**KIRKLEES METROPOLITAN COUNCIL
INVESTMENT & REGENERATION SERVICE**

**DELEGATED DECISION TO DETERMINE PLANNING APPLICATION FOR
ADVERTISEMENT CONSENT**

Reference No:	2023/64/90411/E
Site Address:	The Co Operative Food, 2-4, Station Road, Shepley, Huddersfield, HD8 8AA
Description:	Advertisement Consent for installation of illuminated and non-illuminated signs (within a Conservation Area)
Recommending Officer:	Nicole Helliwell

External _V6_Planning

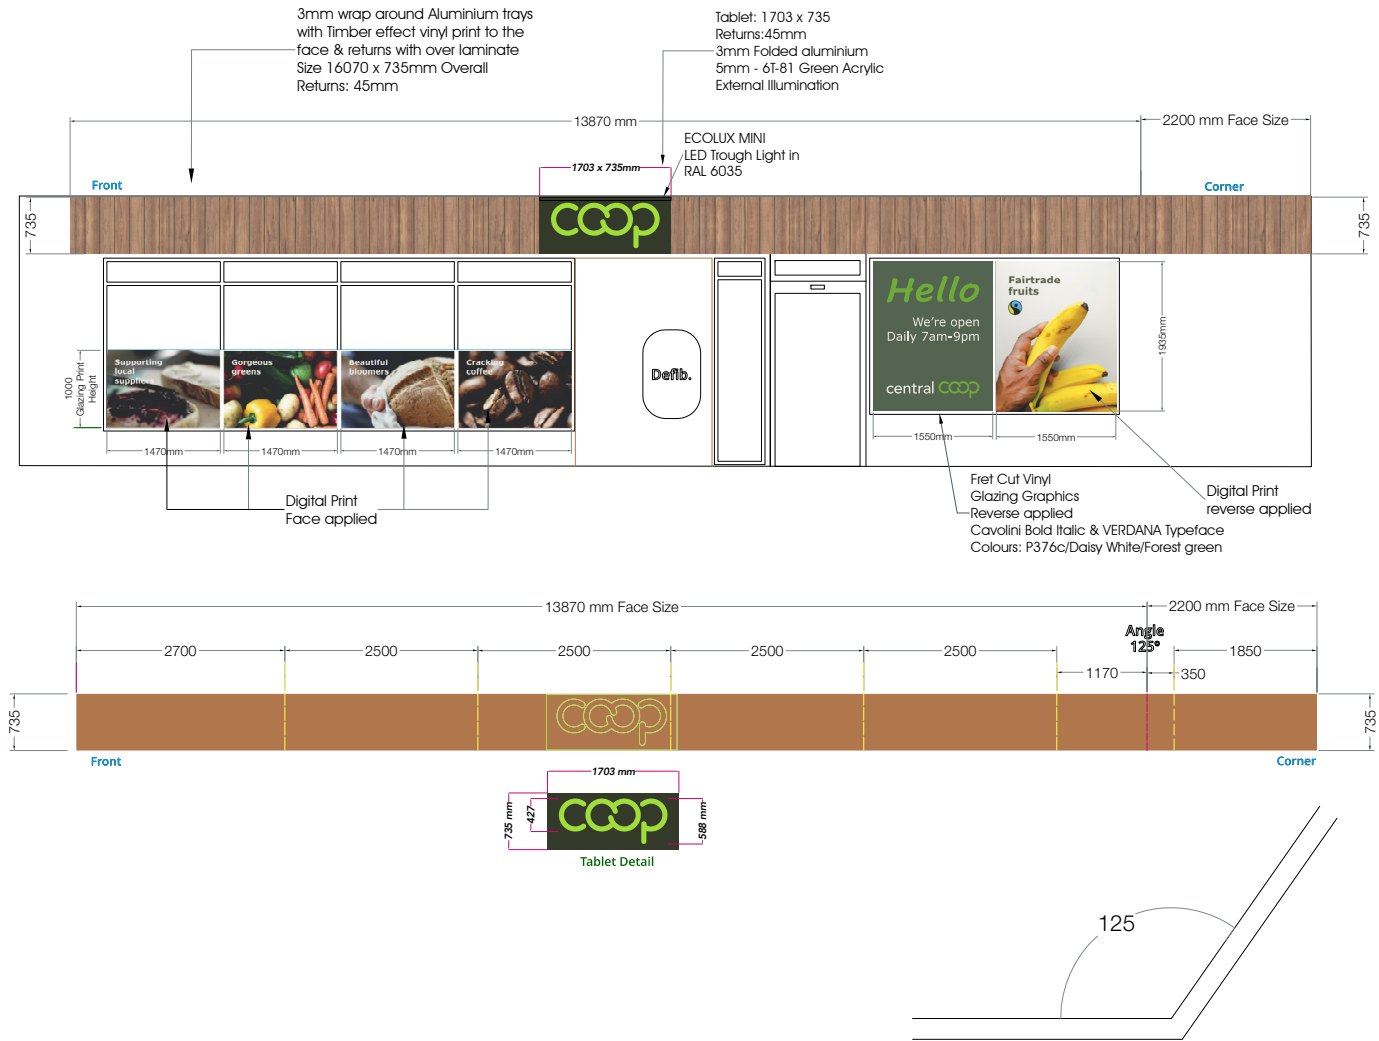
KC Conservation and Design were also consulted on the proposed scheme. Conservation advised that the signage should be externally illuminated and the height of the 'COOP' element should be reduced such that is it flush with the height of the timber effect signage. Following receipt of amended plans, no objections were received.

Furthermore, it is noted that the application site is located within the Shepley Conservation Area. As such, KC Conservation and Design were informally consulted on the proposal. Following receipt of revised drawings, Conservation confirmed that the signage would be an enhancement of the existing and would not result in any detrimental harm to the significance of the setting of the Conservation Area.
